# PLANNING AMENDMENT

| <b>SITE ADDRESS DETAILS</b><br>28 WESTLODE STREET, SPALDING, PE11 2AF.                                         |  |                                                                                                                           |  |
| <b>CURRENT APPLICATION NO:</b><br>This amendment cannot be considered unless the relevant reference is stated. |  | H16 - 0208 - 26                                                                                                           |  |

| <b>FULL DESCRIPTION OF DEVELOPMENT OF CURRENT APPLICATION THAT THIS AMENDMENT RELATES TO</b>                                                                                             |  | CHANGE OF USE FROM CAFE TO |   |

Drawing Title:
PROPOSED GROUND FLOOR PLAN AND ELEVATIONS.

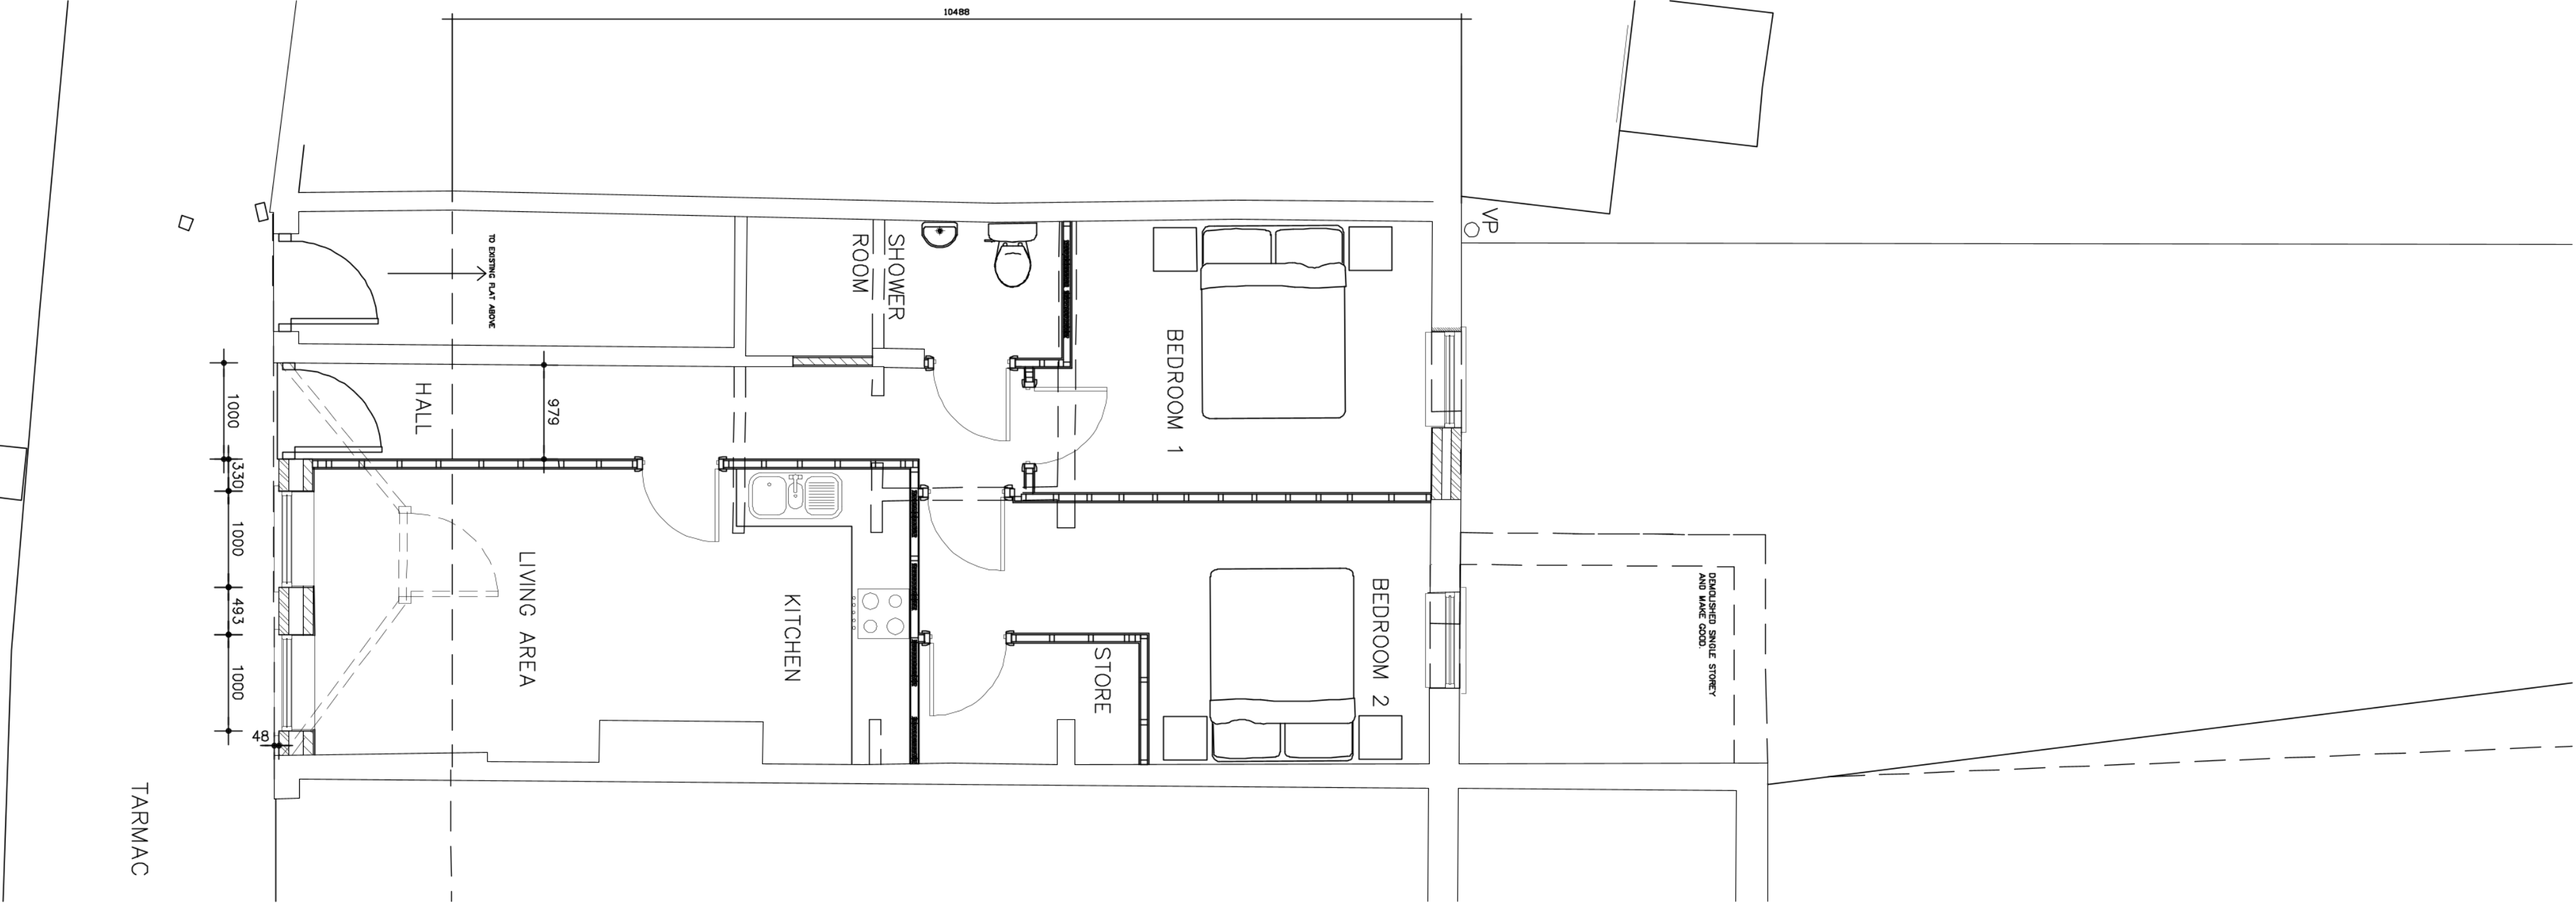
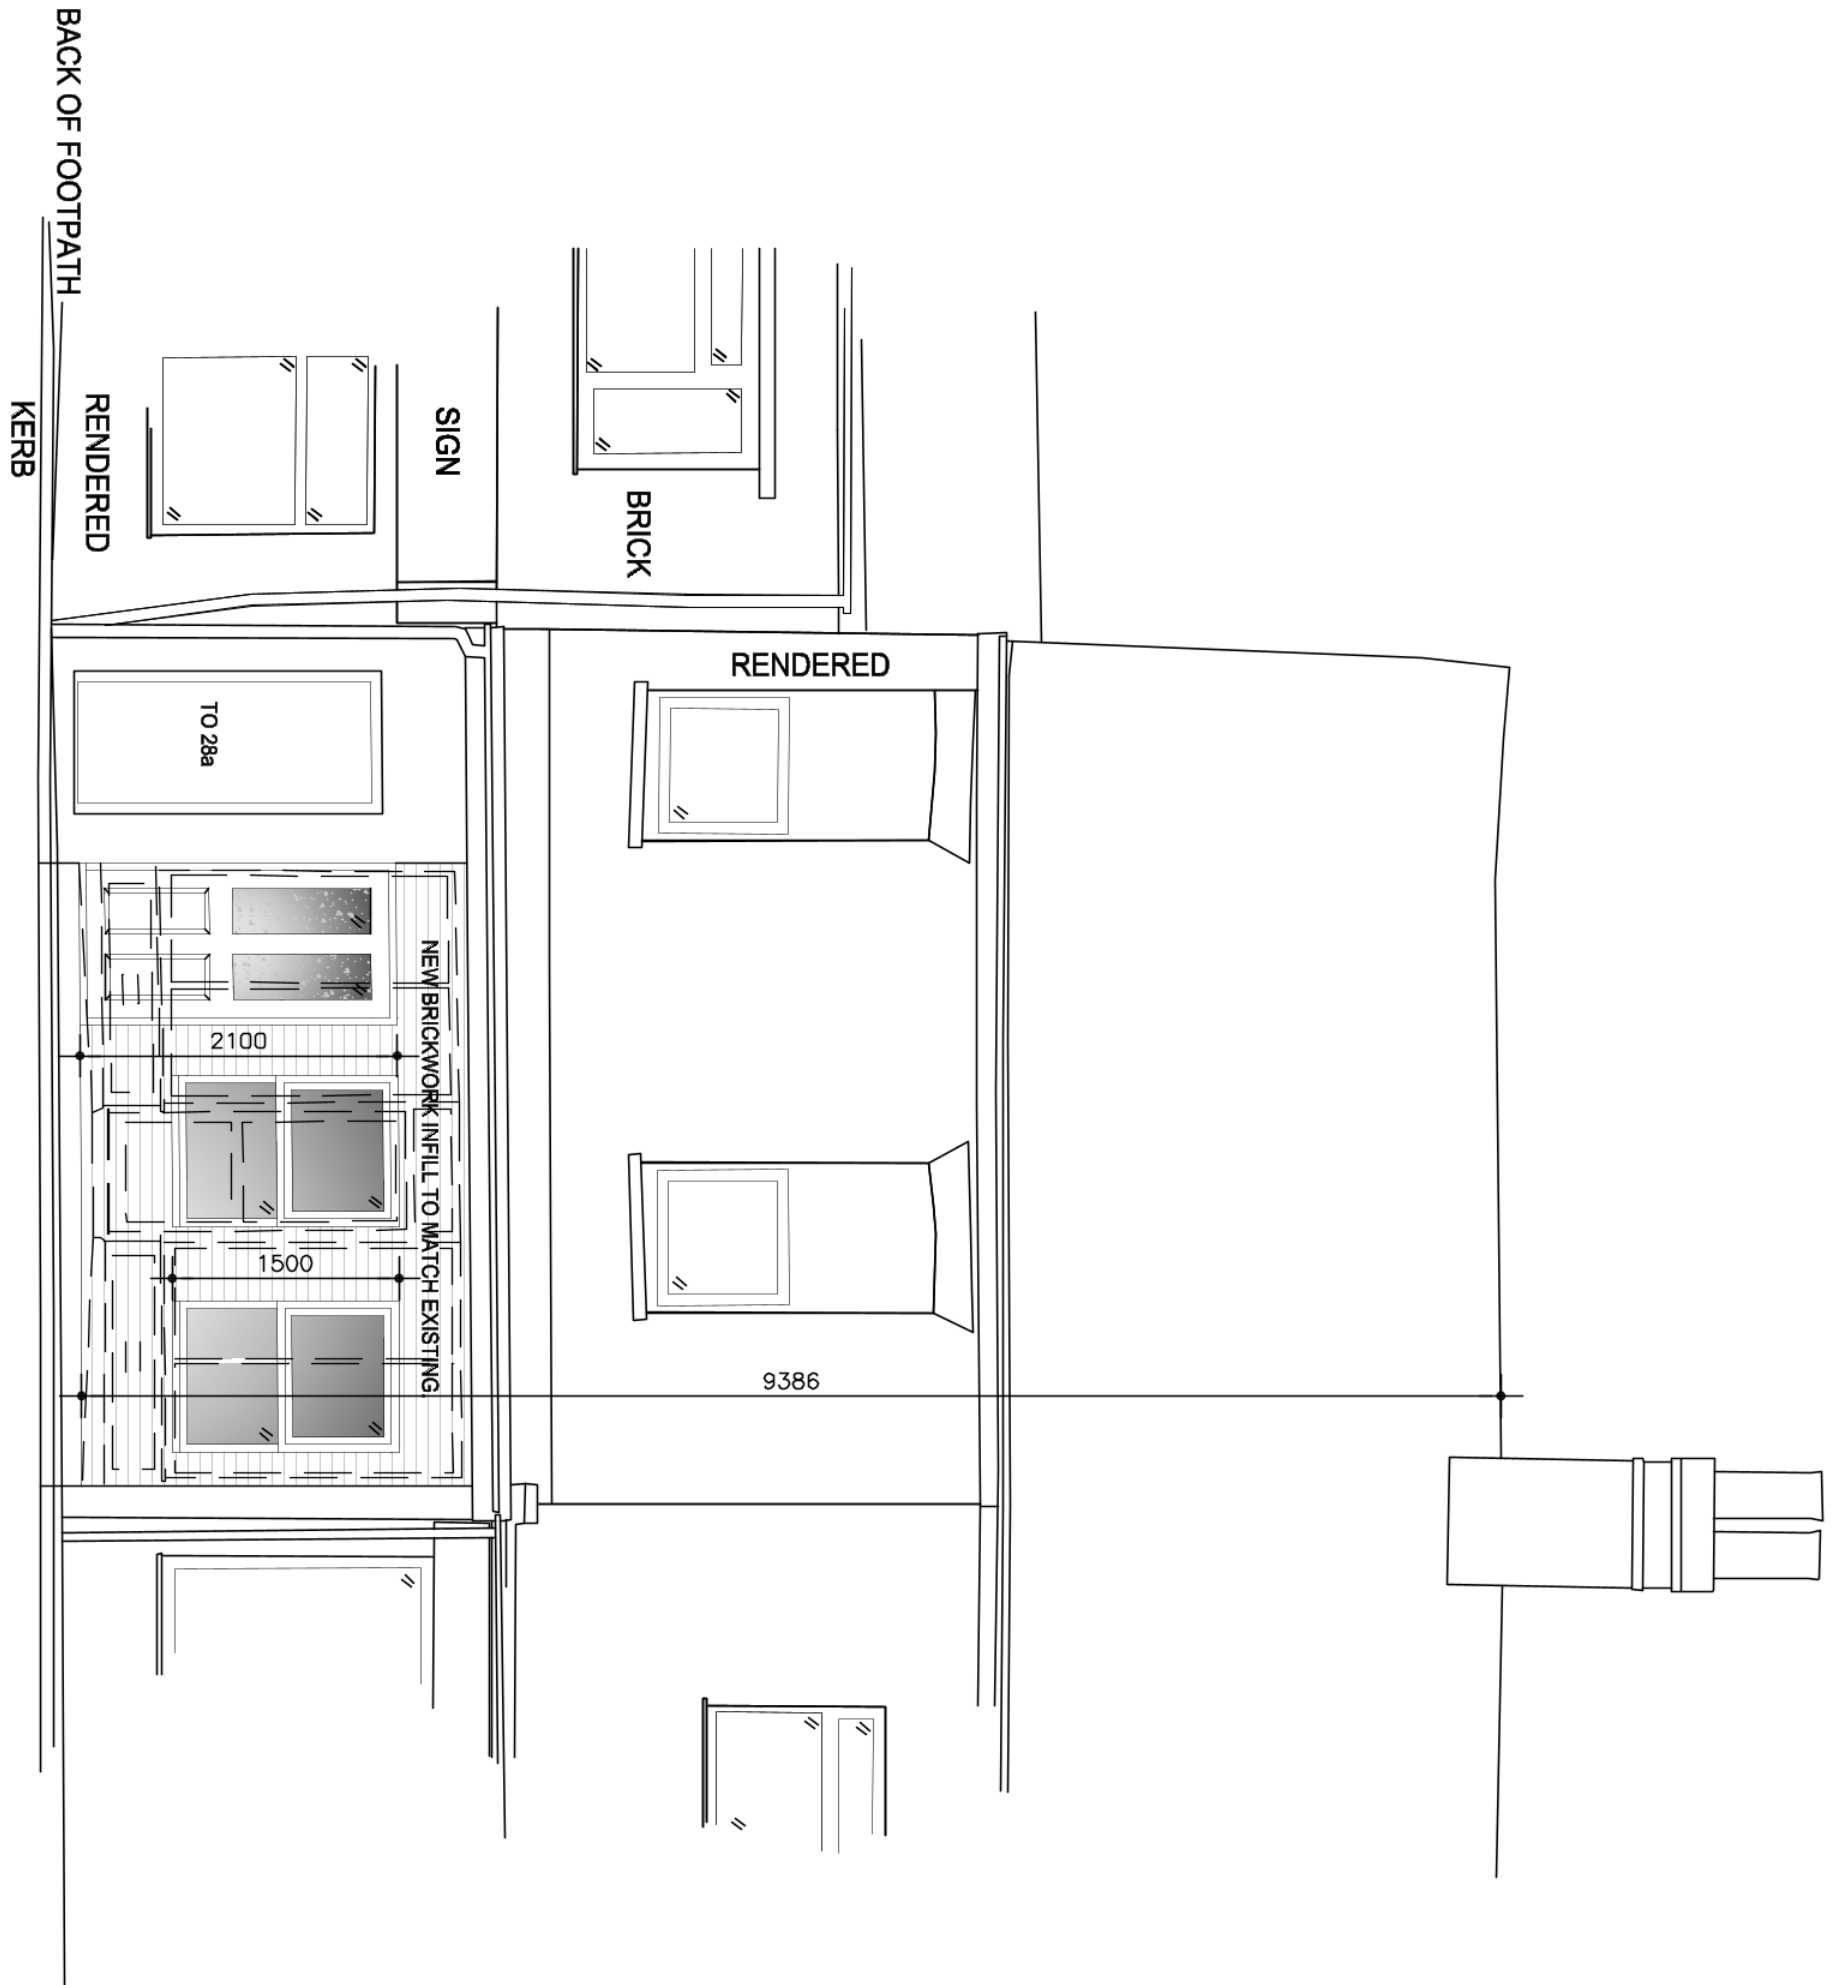
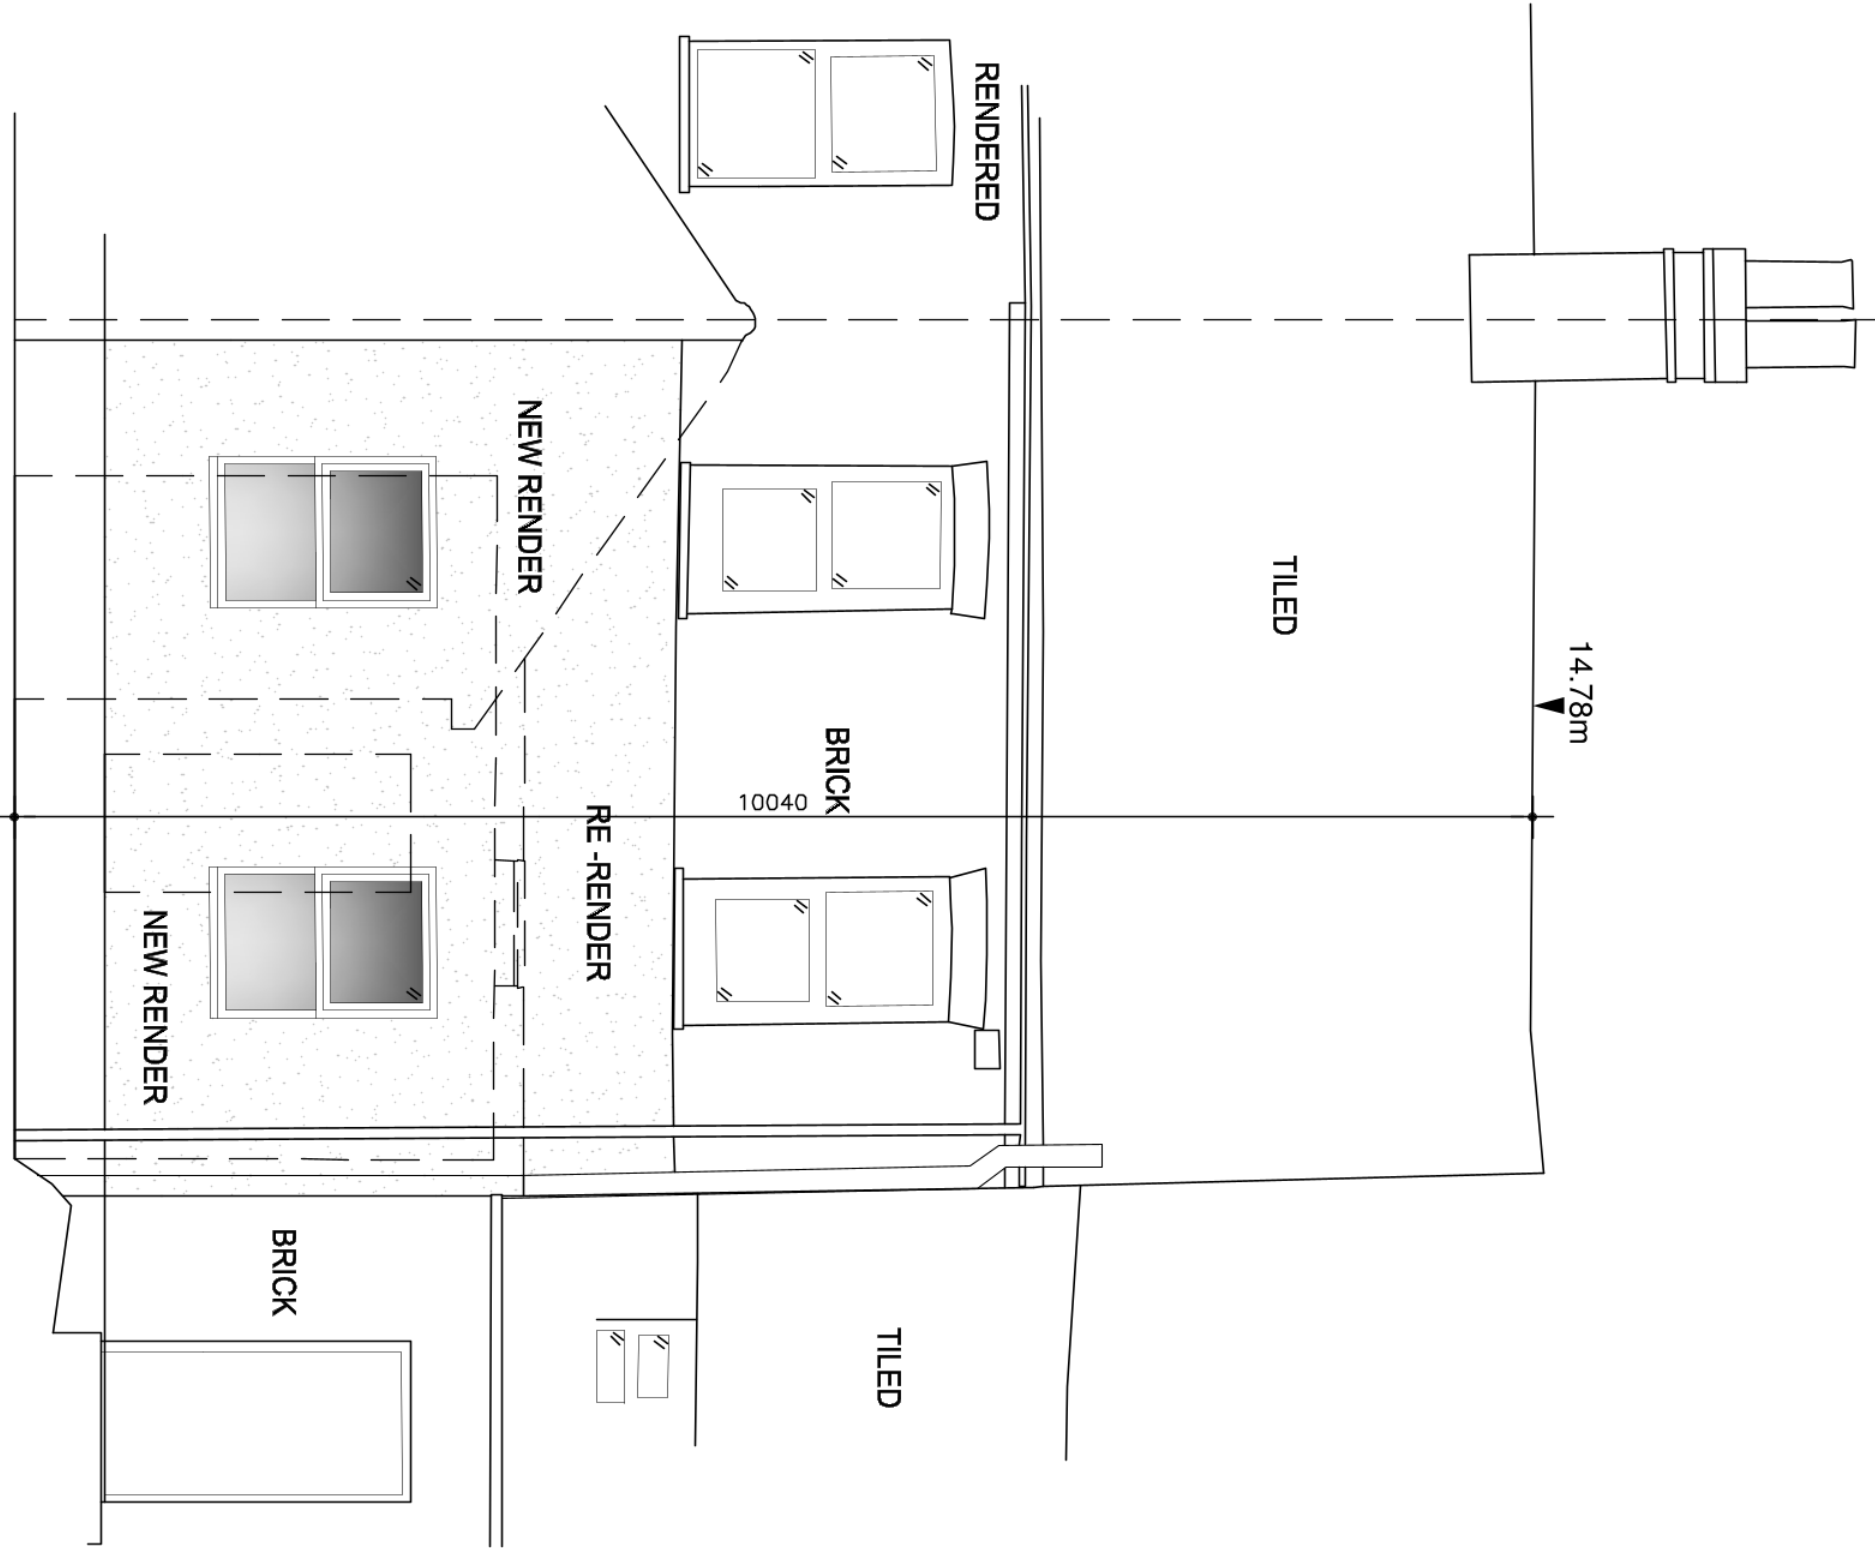
| State details of amendments proposed. (Give a full detailed list of the changes, and also mark these clearly on the accompanying plans. Only the changes listed here will be considered) |  | CHANGES CARRIED OUT AS     |   |
| Describe any part of the original development which is excluded by virtue of the amendment, and state any alteration to plot numbers                                                     |  | FRONT ELEVATION FLAT DOOR  |   |
